### **Re: A portion of 4 Way Ranch – Phase 2 (the “Project”) – Fire Protection to Serve Letter**

**Re: Conditional Commitment to Provide Emergency Services  
Property: A portion of 4 Way Ranch- Phase 2**

# Markup Summary

**1 PRIVATE ROADWAY GATE DETAIL**  
GATE DETAIL      NTS

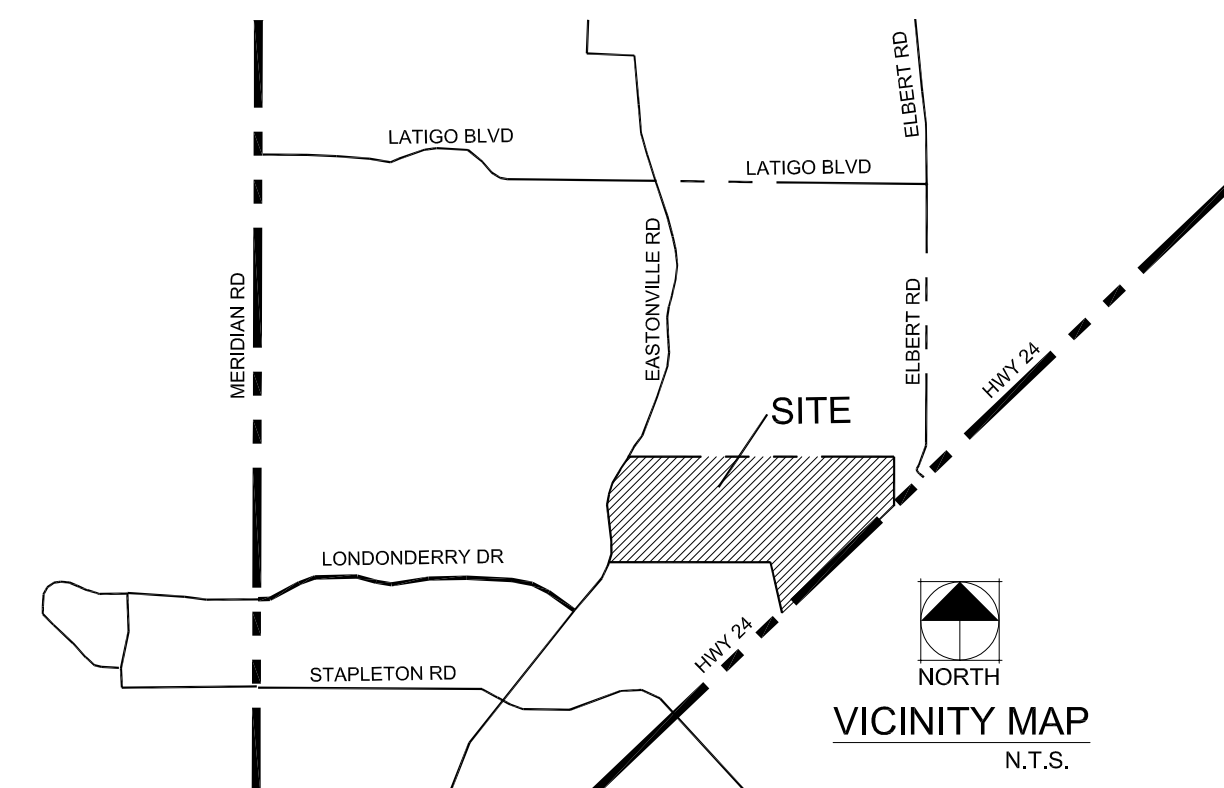
Gate type? private rd width? Are they in agreement? please state so..

Gate type? private rd width? Are they in agreement? please state so..
